RE: 780 Wallgrove Road, Horsley Park SSD-9601 Modification – Response to Submission - Transport Statement

Reference has been made to the Fairfield City Council's (Council) response sent on 02 May 2022 in relation to Modification (MOD 1) for SSD-9601 at 780 Wallgrove Road, Horsley Park (the Site). In this regard, Brickworks Land & Development (Brickworks) have commissioned Ason Group to prepare a response to the Council comments. Details of our assessment are as follows.

ACCESS RAMP B
1 : 250

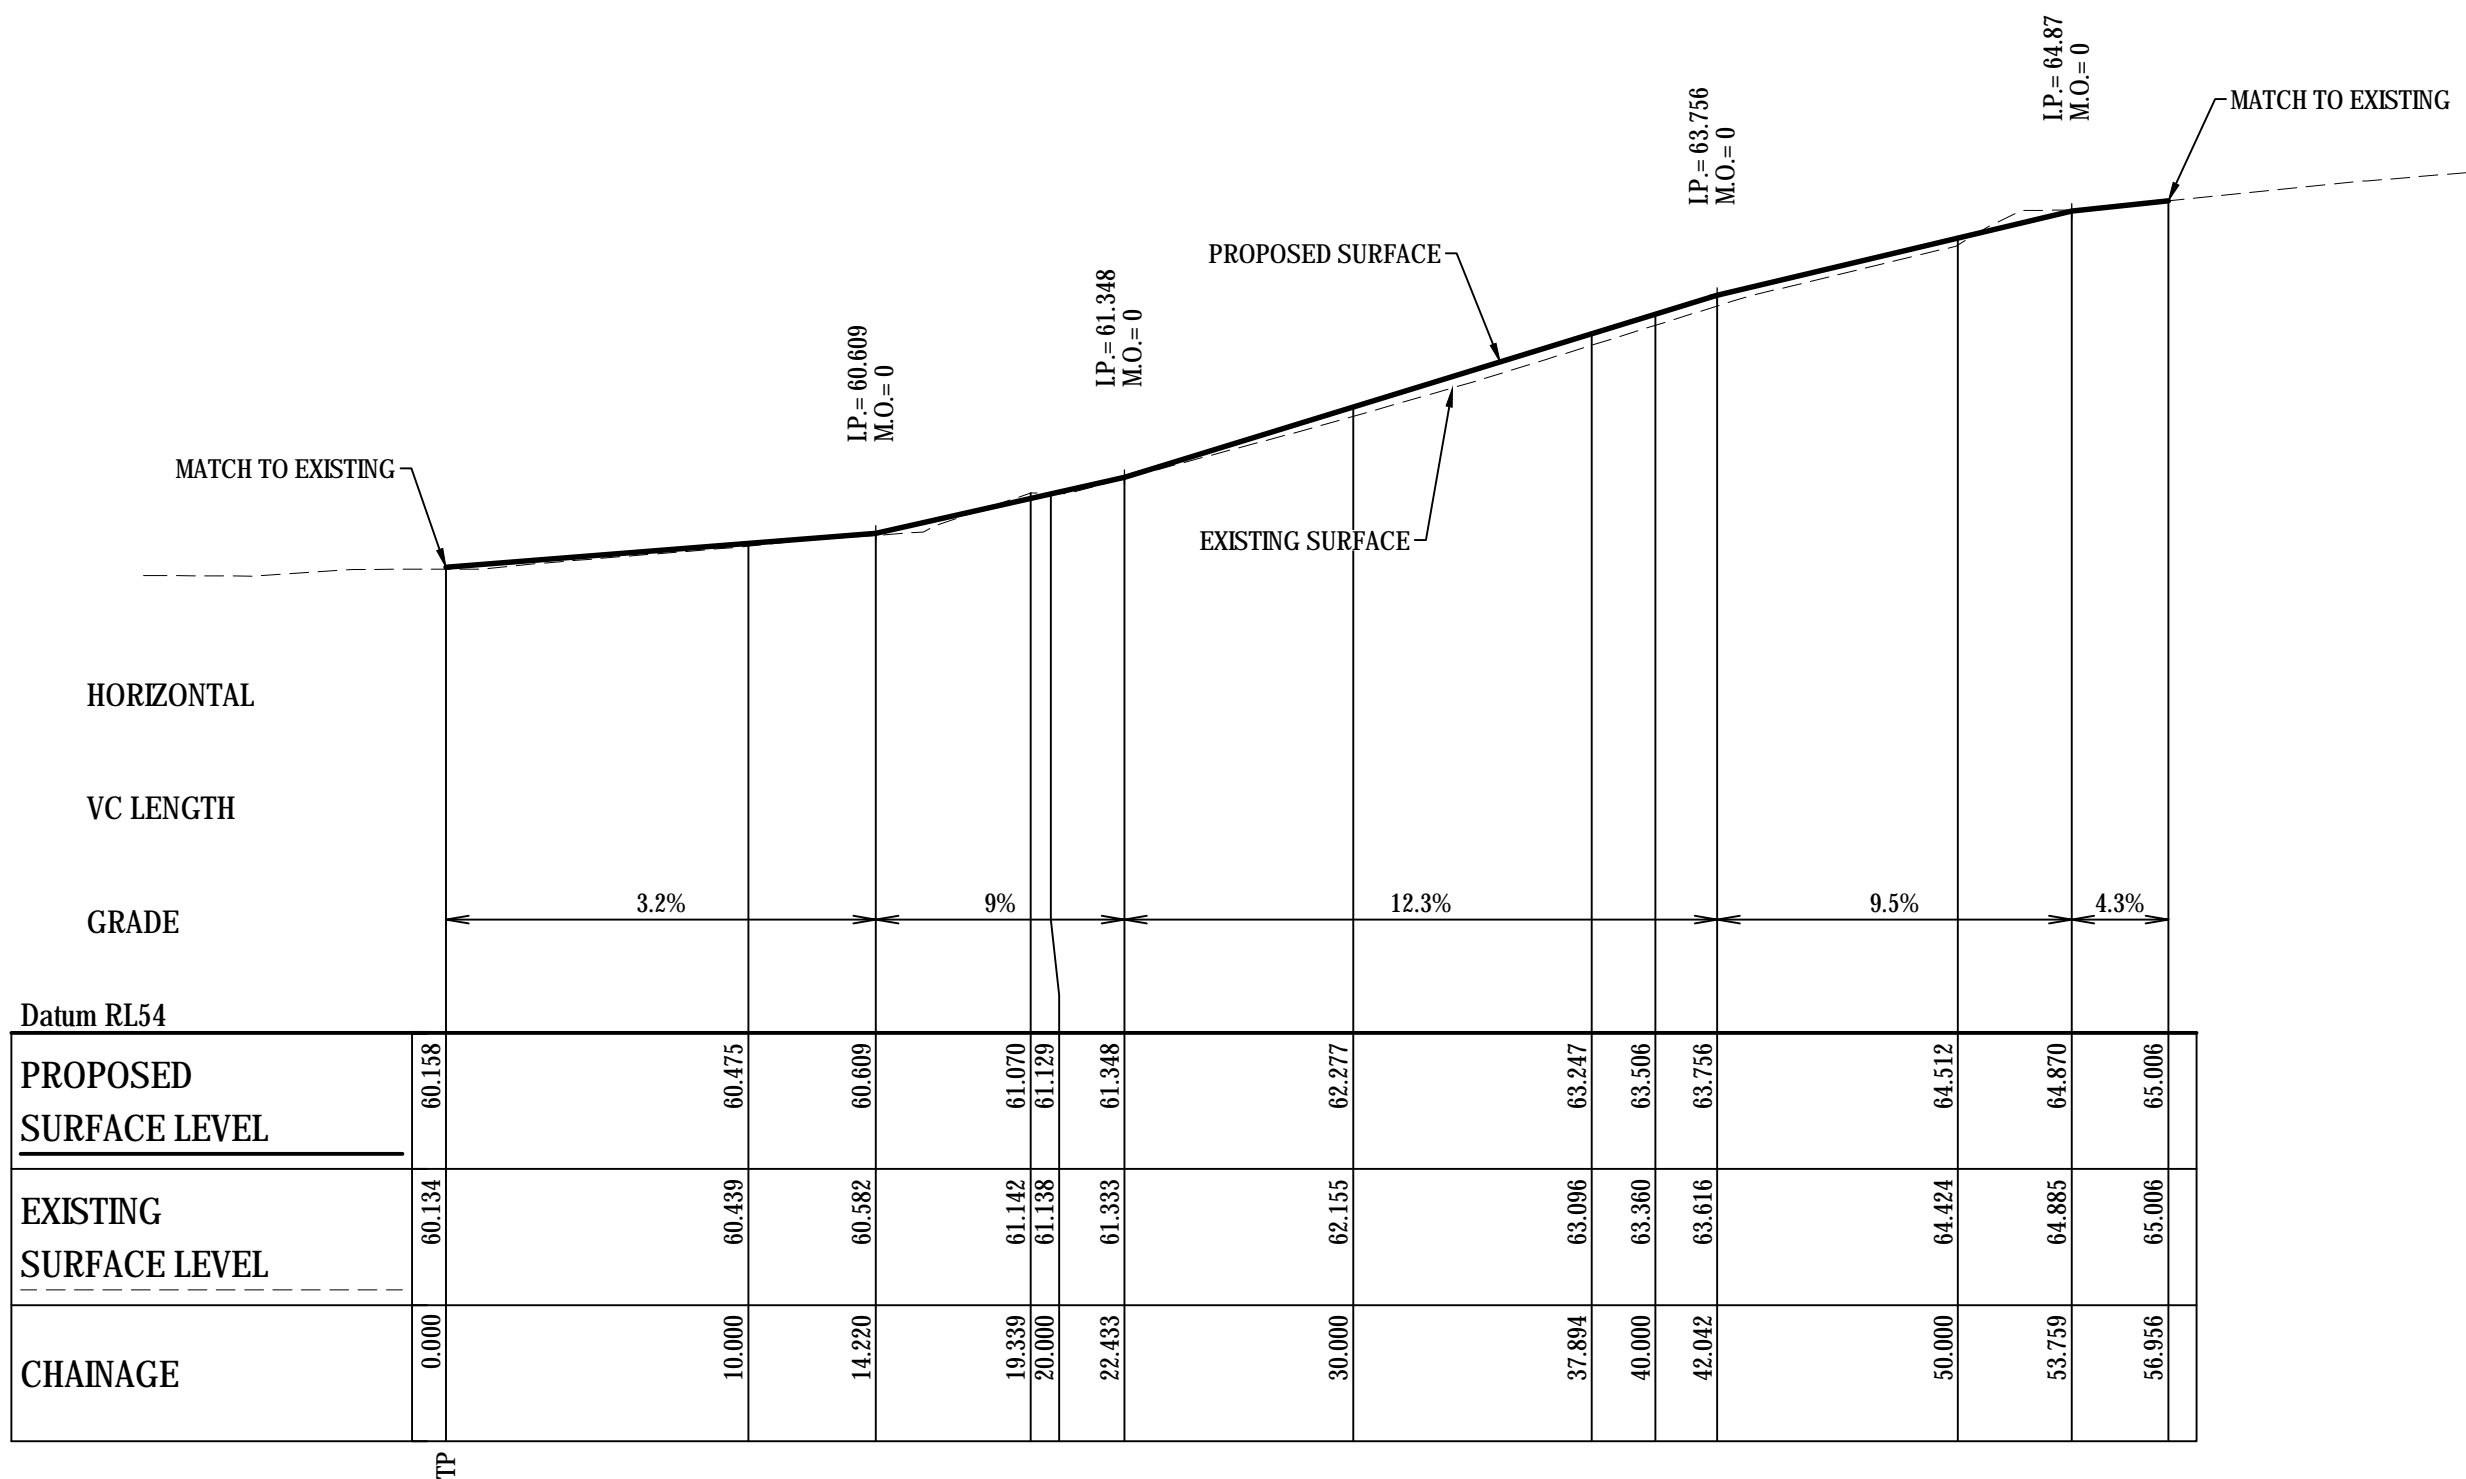
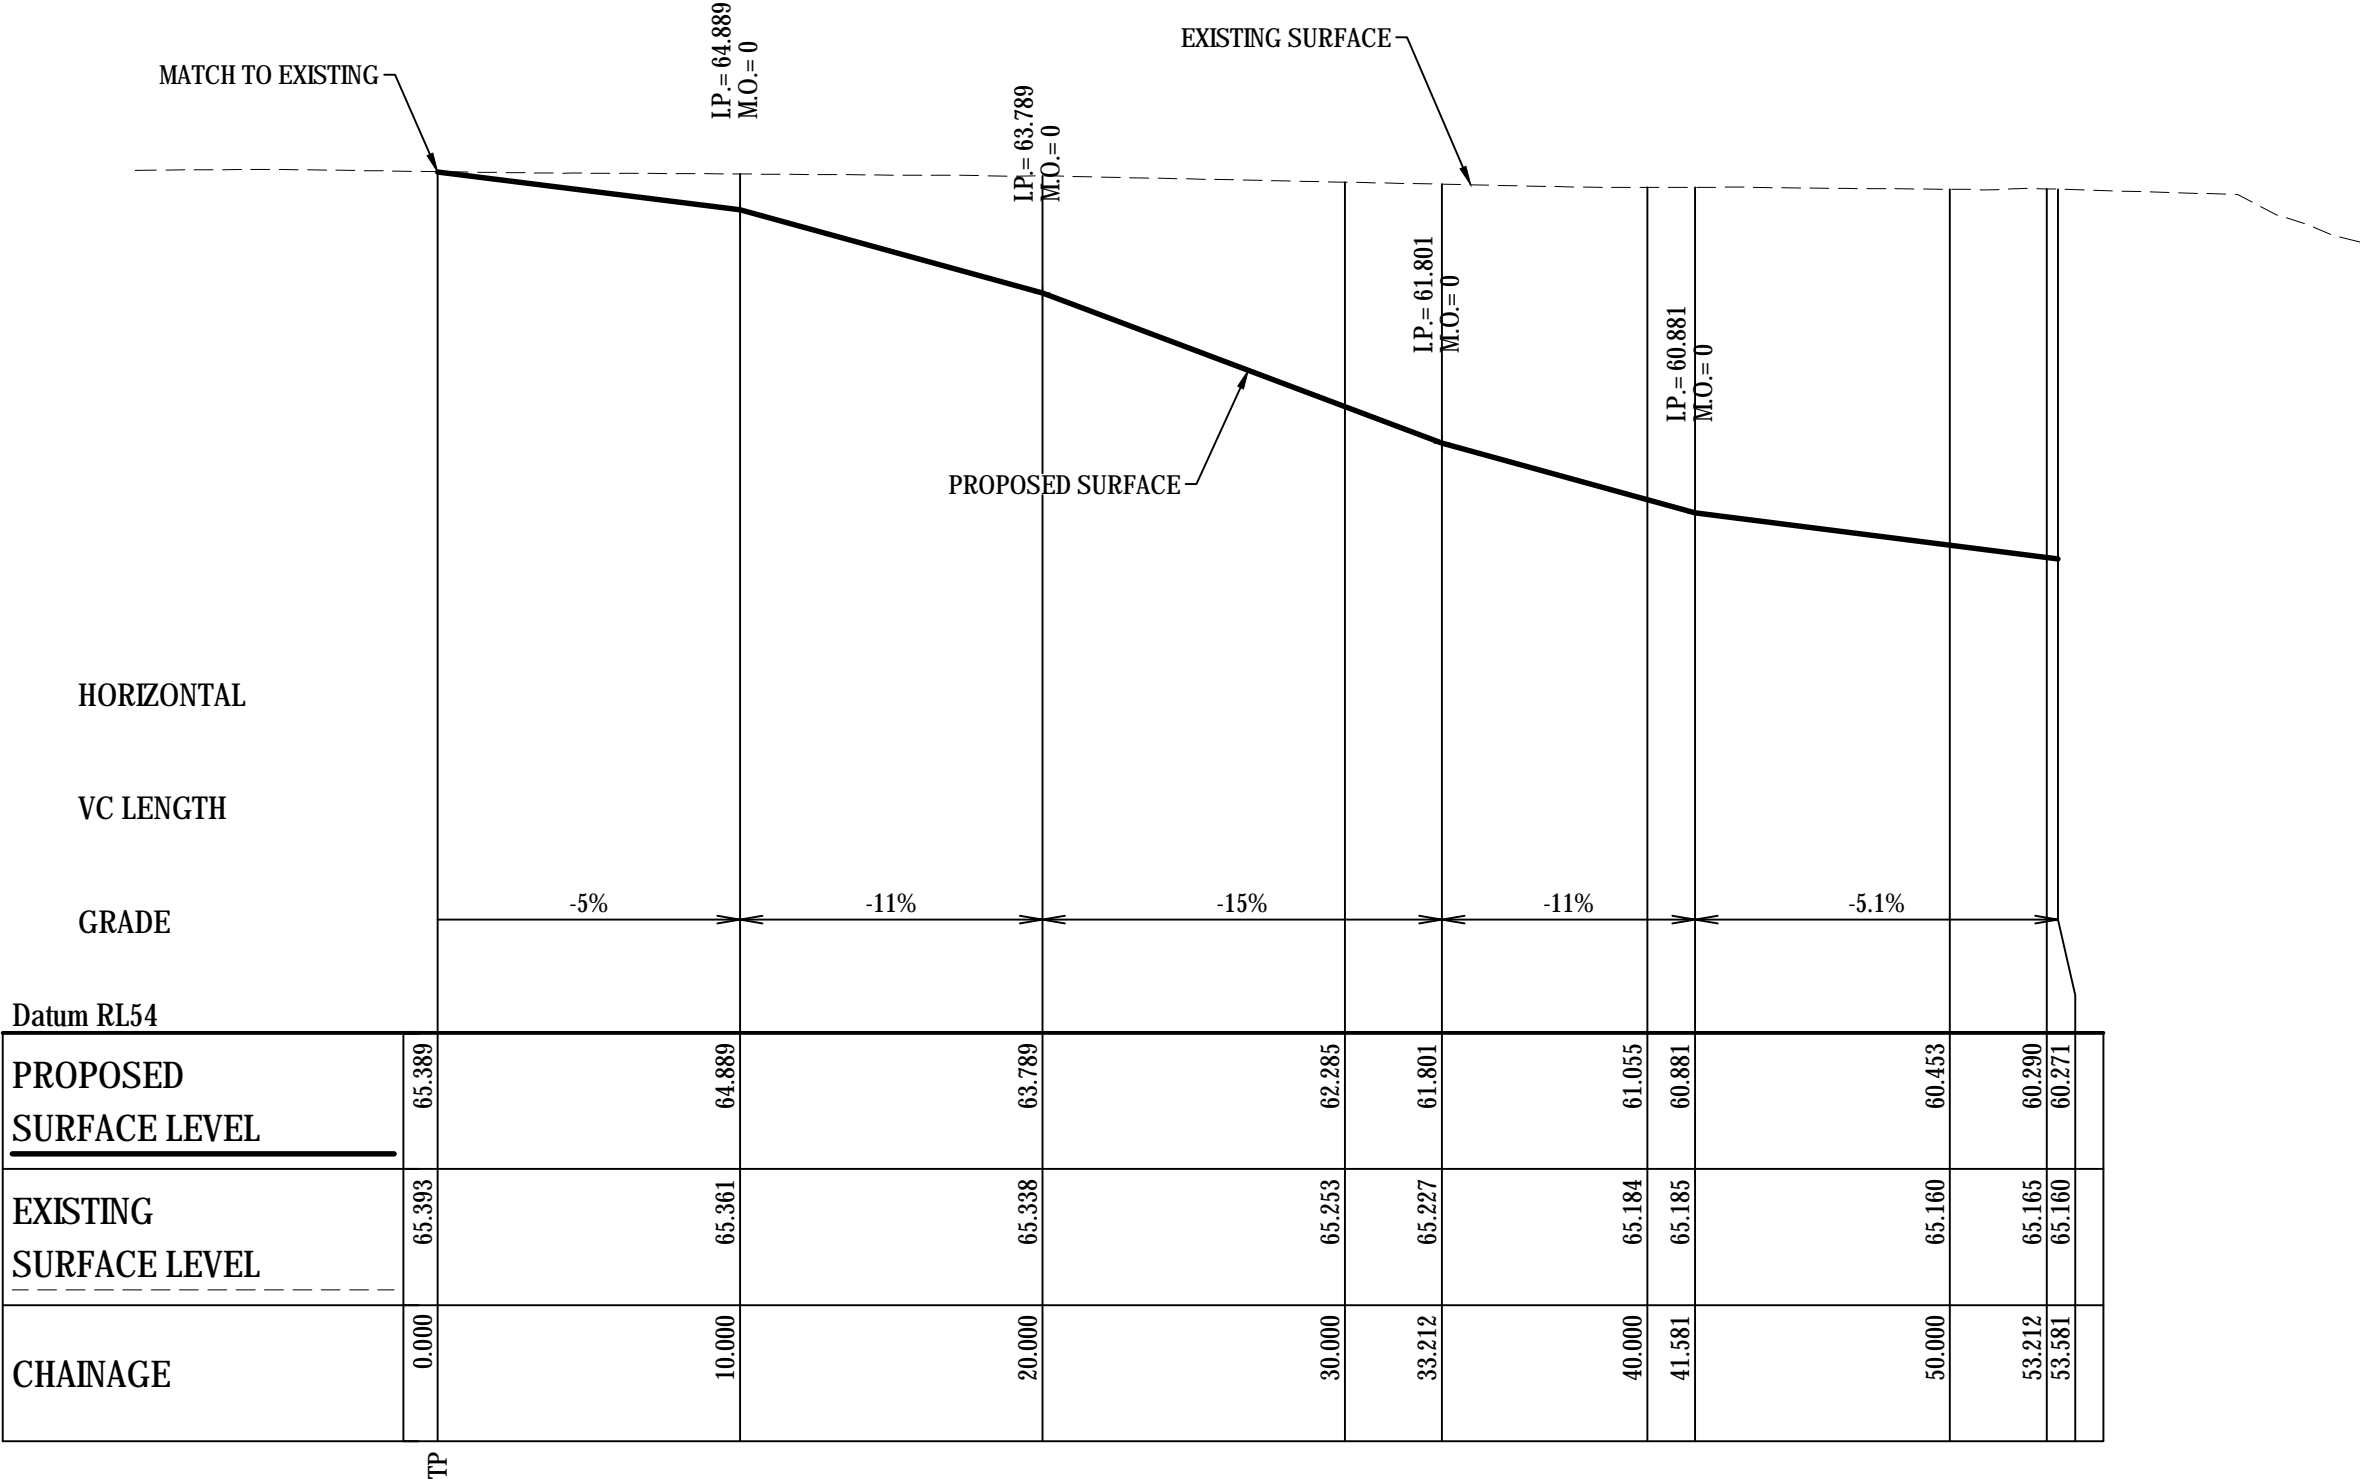
“Australian Standards (AS 2890.2:2018) does not specify a requirement for the maximum permissible allowable ramp grade for 26m B-Double vehicle. The applicant shall carry out investigation and submit additional information to Council for assessment regarding this matter;”

AS2890.2:2018, Table 3.2 stipulates the following regarding maximum grade of 26.0m B-Double vehicles.

As seen above, the maximum allowable ramp grade for a B-double vehicle is 1:8.3 (12%) and the maximum rate of change is 1:15 (6.25%) in 10m of travel. The proposed driveway has been designed in accordance with the above.
